KITTITAS COUNTY

DEPARTMENT OF PUBLIC WORKS

MEMORANDUM

TO: All Staff
FROM: Zachery Peebles, Engineering Technician I
DATE: November 25, 2019
SUBJECT: Hiatt CB-19-00019
Tax Parcels: 480434 and 490434

# Proposed lot lines (without center property line)

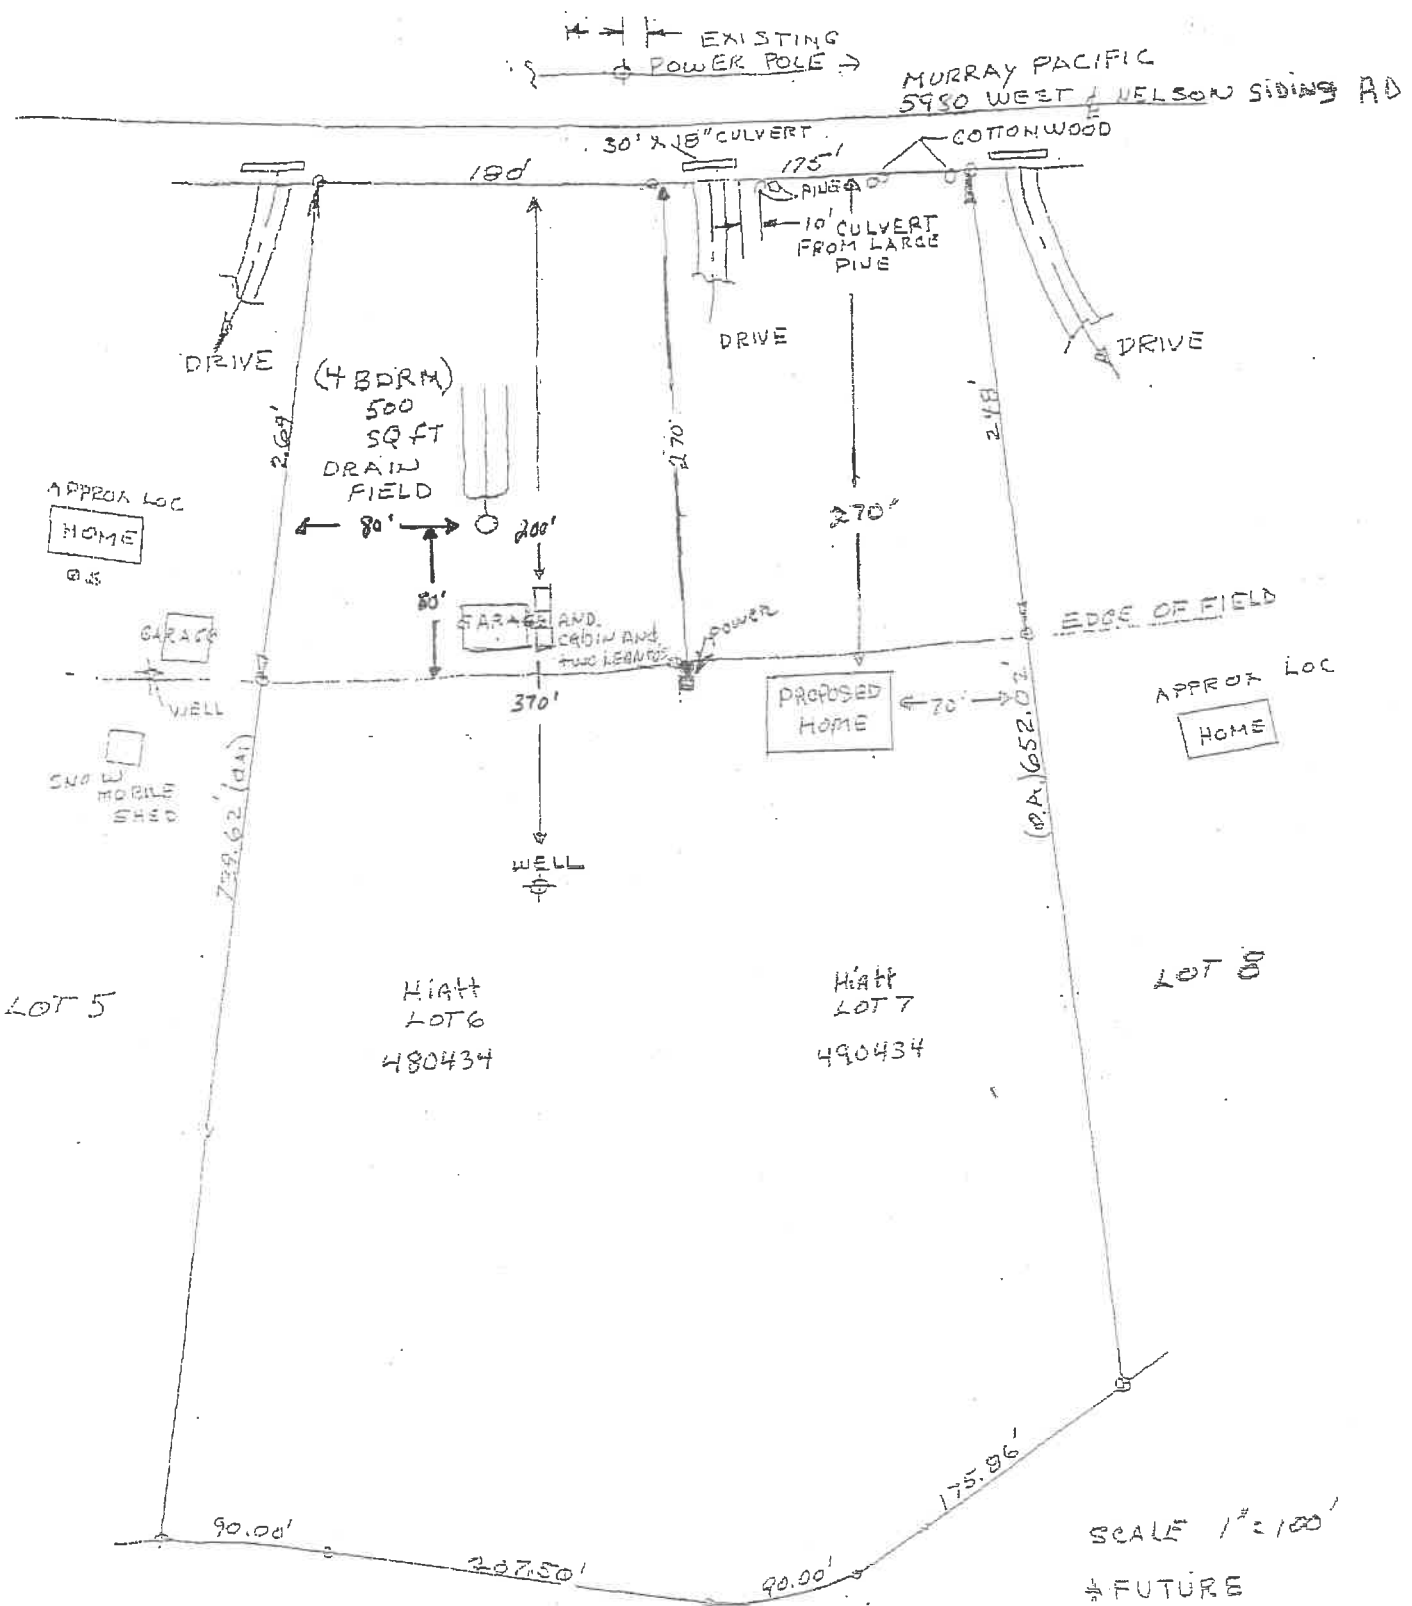
- a) An approved access permit shall be required from the Kittitas County Department of Public Works prior to creating any new driveway, access or performing any work within the county road right of way.
- b) The parcel combination will use the existing access for parcel 490434.
- c) Any further subdivision or lots to be served by proposed access may result in further access requirements. See Kittitas County Road Standards.
